RE: Nathan Clifford Redevelopment – Portland, Maine

Following are responses to your comments on our team's application for permit:

3 | EXISTING TRANSOM WINDOW SECTION - RECONDITIONED

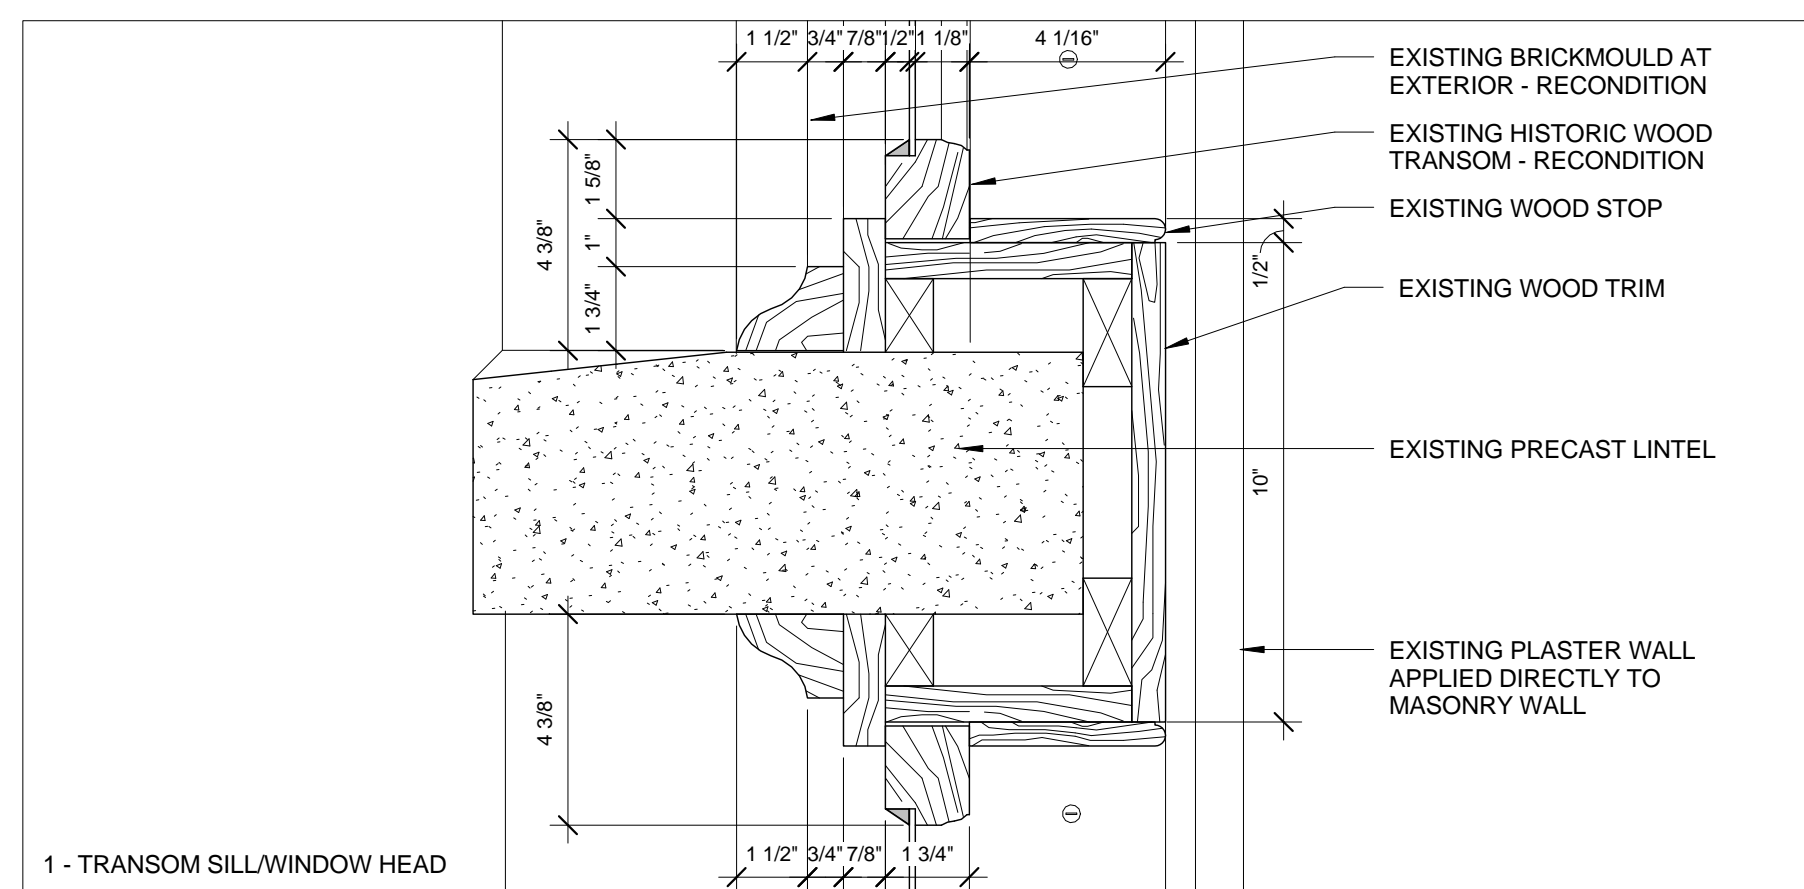
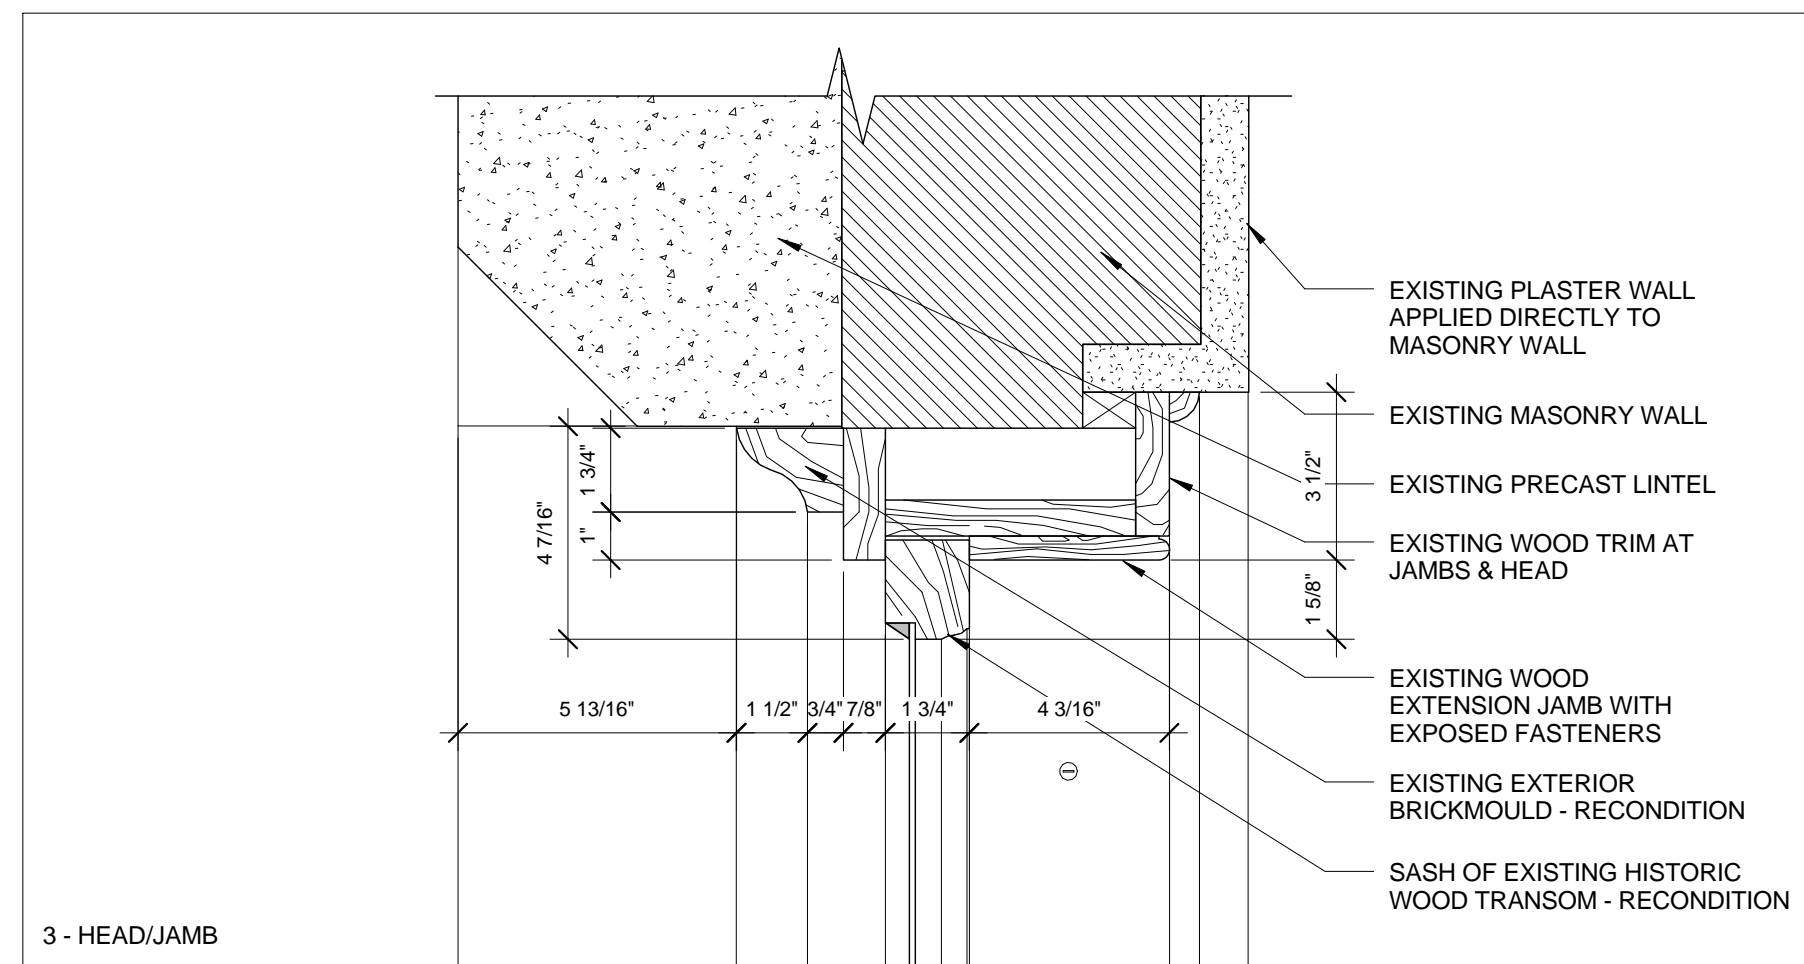
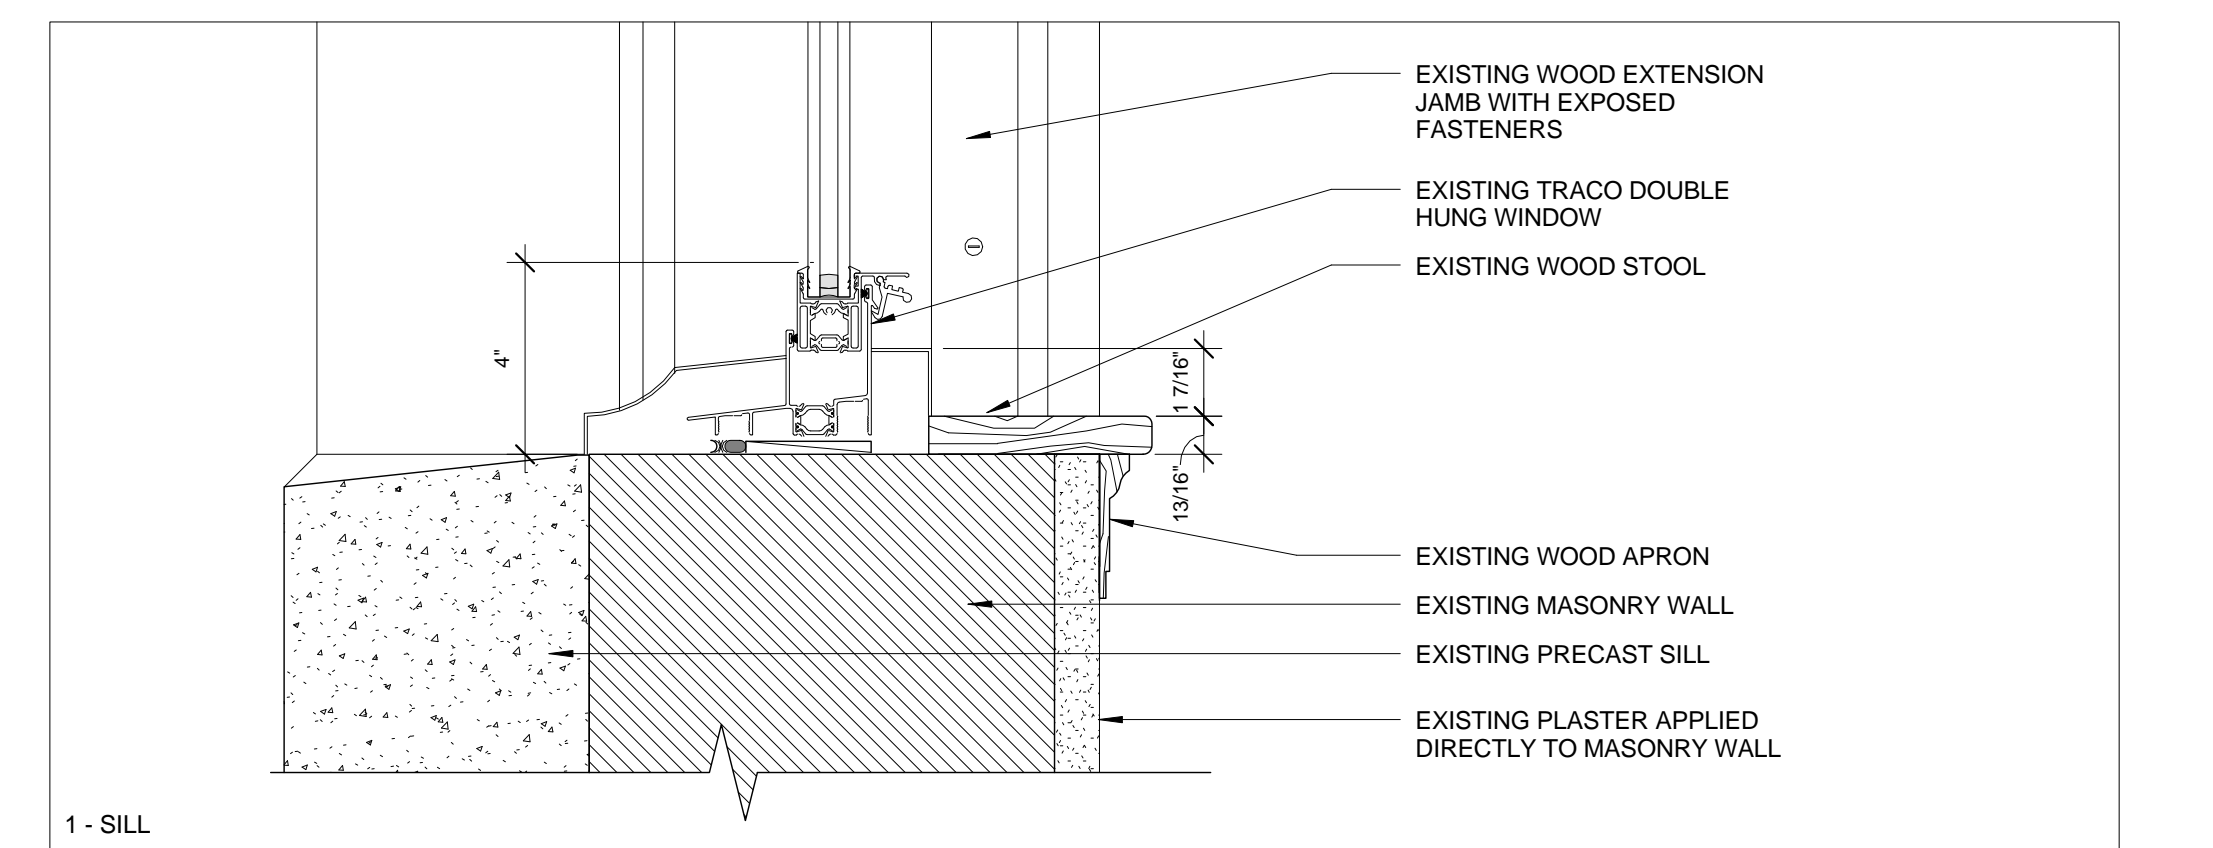
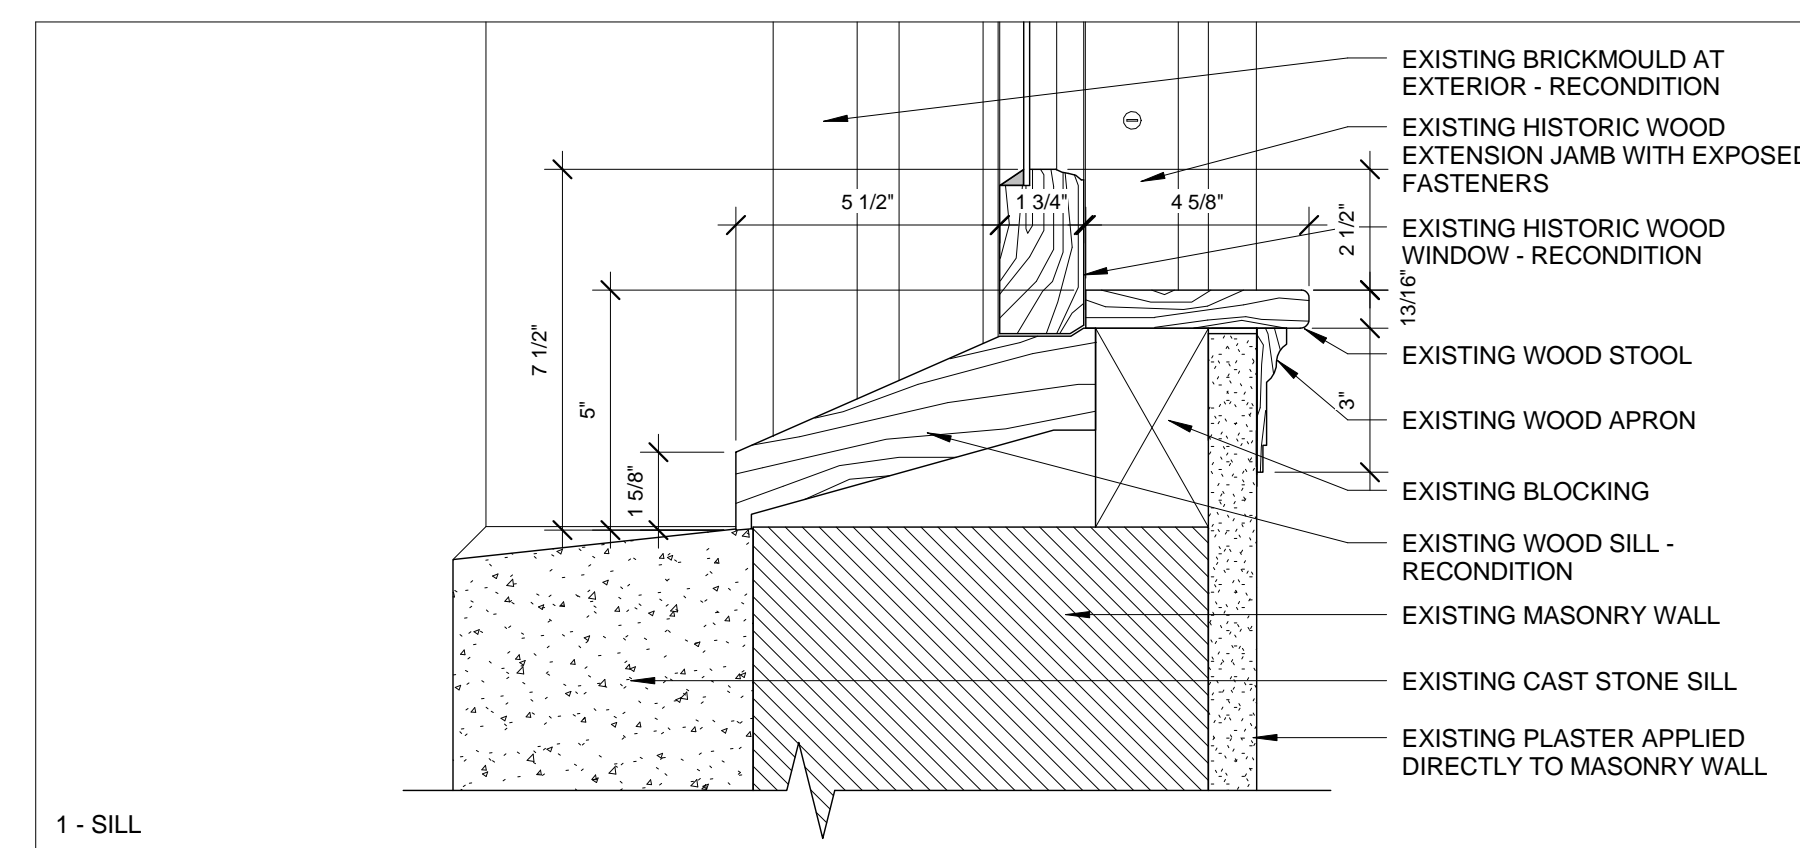
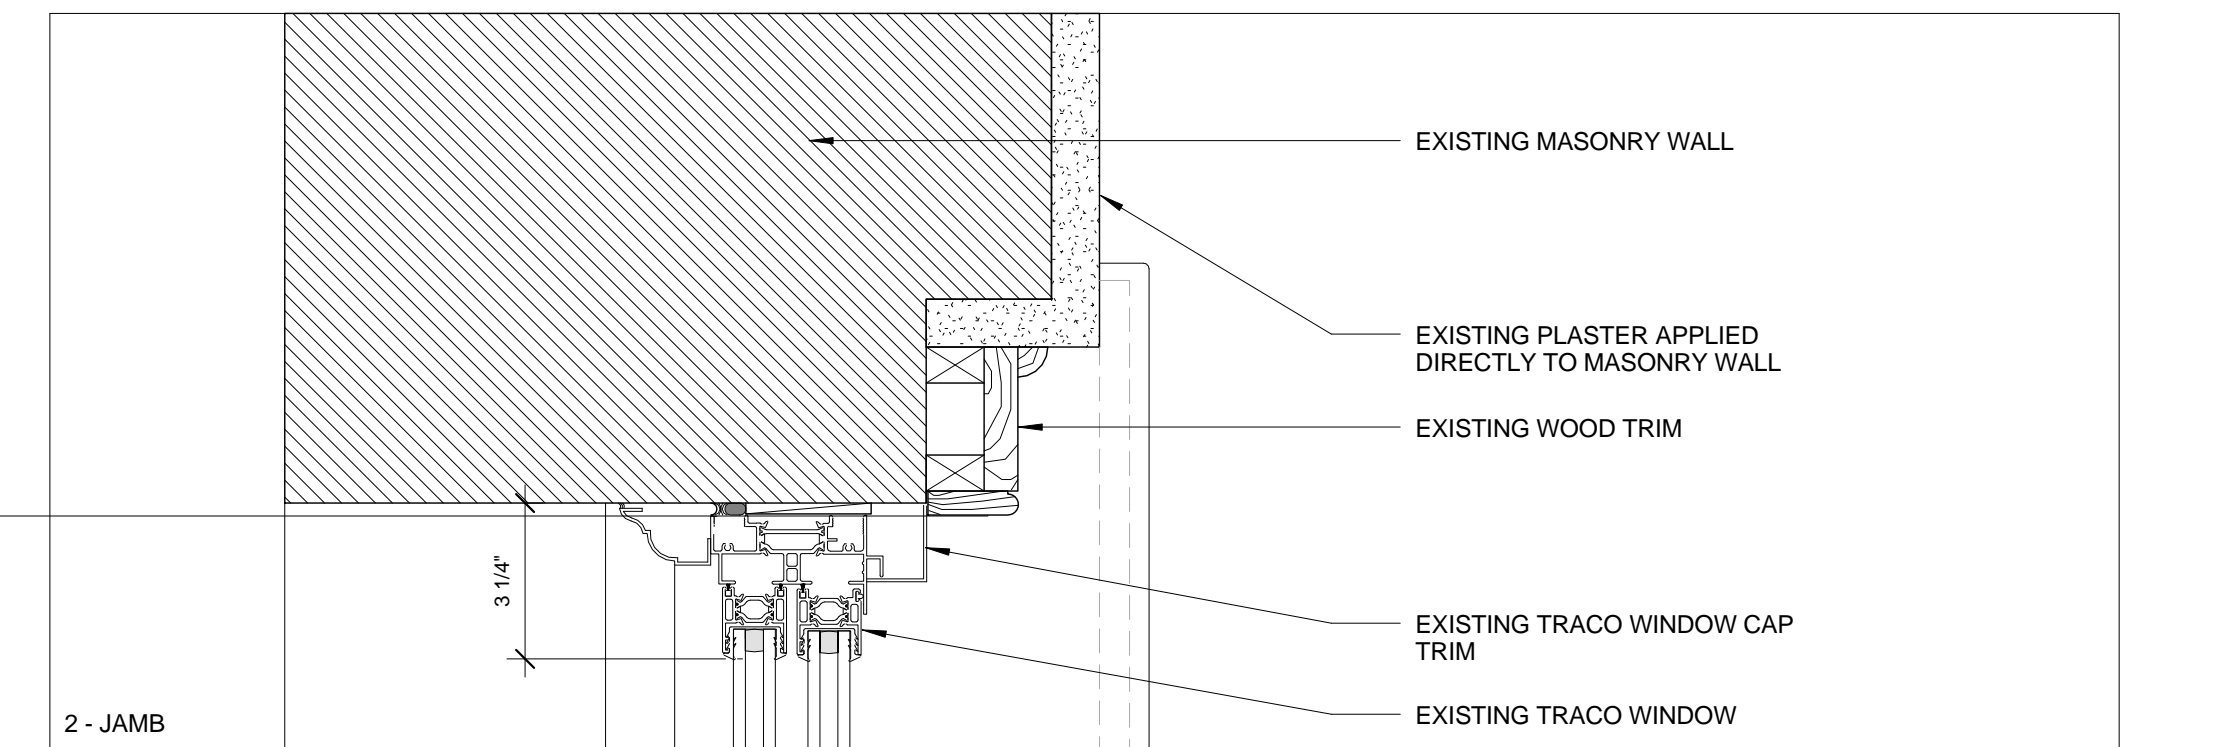
“Window Glazing/Transoms

See Table 1018.1 for corridor partitions allowed to be .5 hour and Table 715.5 for window ratings in fire partions to be 1/3 hour, 20 min.”

Response: Transoms in historic buildings are not required to comply with assembly requirements of this code.

“Section 3409.1 Historic buildings. The provisions of this code relating to the construction, repair, alteration, addition, restoration, and movement of structures and change in occupancy shall not be mandatory for historic building where such buildings are judged by the building official to not constitute a distinct life safety hazard.”

It is our view that the NFPA 43.10.4.5 specifically exempts existing transoms in historic buildings. In addition transoms will be sealed to prevent smoke movement; therefore we feel this does not create a distinct life safety hazard.

Amended Response: Though allowed by code, it has been requested by Captain Pirone that we take a second look at the proposed transom conditions to remain. Upon further review, we have documented in four locations, the transoms to remain in the proposed corridor have previously infilled with wood panels and are no longer glazed. The attached sketch shows additional layers of gypsum applied to the transom panel to provide the required rating. Also shown in the attached sketch, the half lite wood door at these same locations, previously proposed as to remain, are called for to be removed and replaced with a rated unit door or fixed in place and fortified with an infill rated wall at the unit side. All other existing doors and transoms to remain are not located in proposed corridor walls.
